FIVE ESTUARIES OFFSHORE WIND FARM

Appendix M3 to the Natural England Deadline 4 Submission

**Natural England's comments on Examining Authority's Written Questions [PD-001]
(ExQ1) ME. 1.01 (relating to Fish Ecology and Marine Mammal Ecology)**

03 December 2024

Figure 5.4: Results of the harbour seal iPCoD simulations for monopile foundations at Five Estuaries alone assuming a declining population.

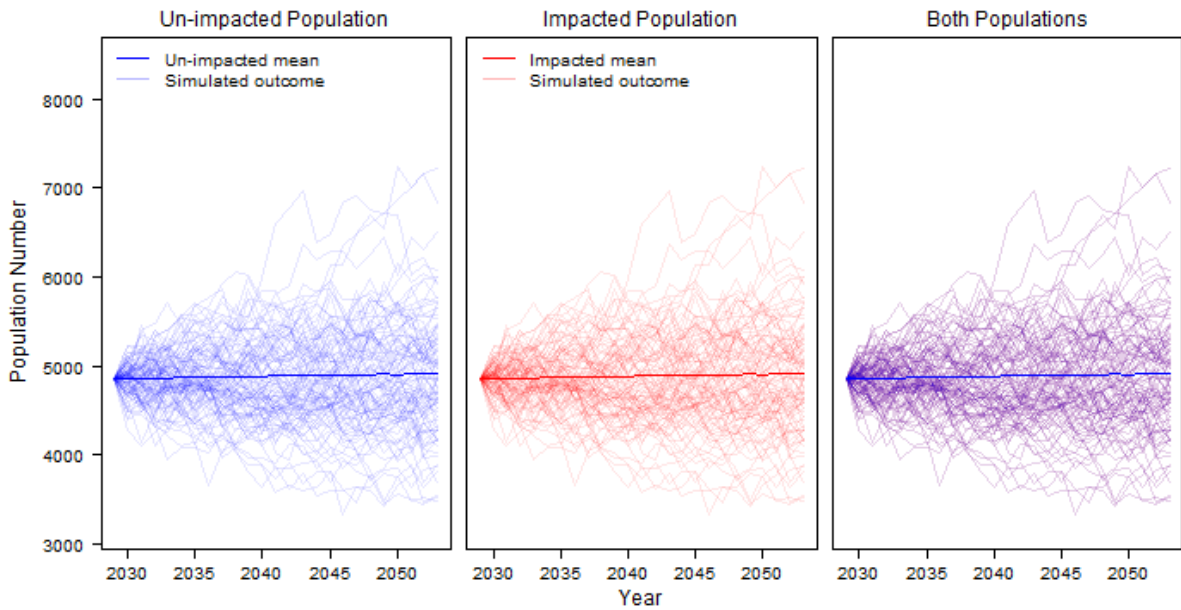
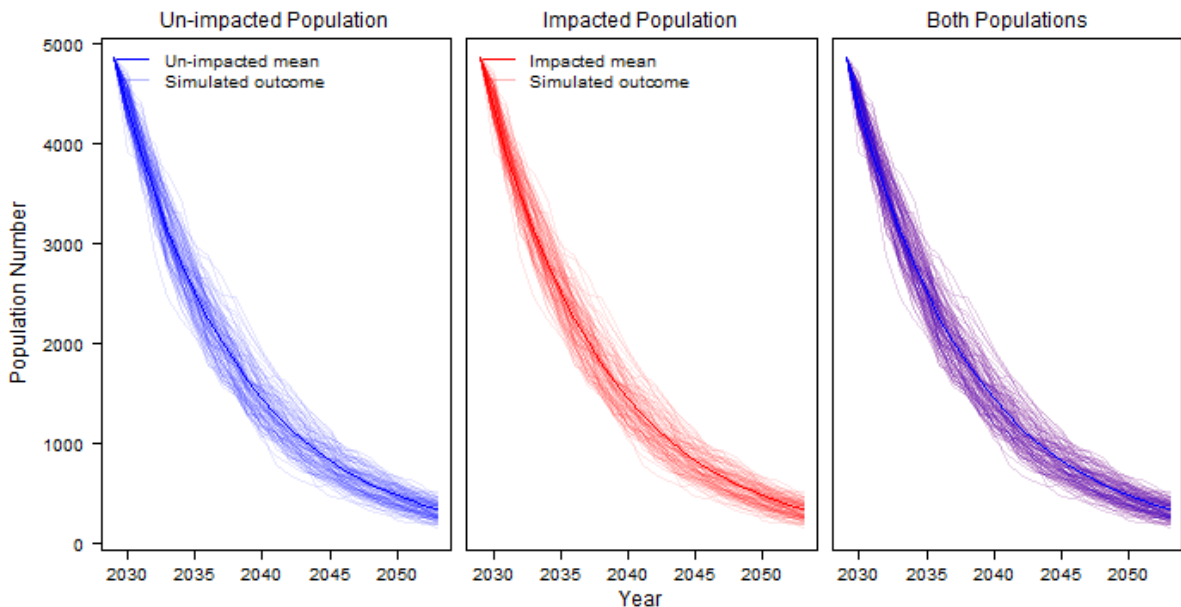
<p>alone, the site-survey density is the most representative.</p> <p>Natural England notes that the Applicant conducted iPCoD modelling for two scenarios for harbour seal i.e. stable and declining population. Given that the population remains in decline, the latter scenario is the most appropriate. Currently, the cause of the decline of harbour seals in the Wash and North Norfolk Coast (WNNC) SAC is unknown; until the cause of the decline is found, any activities that have the possibility to hinder recovery need to be carefully assessed for less impactful alternatives (such as the use of noise abatement or other suitable alternative to reduce sound at source).</p>
--	--	--	--
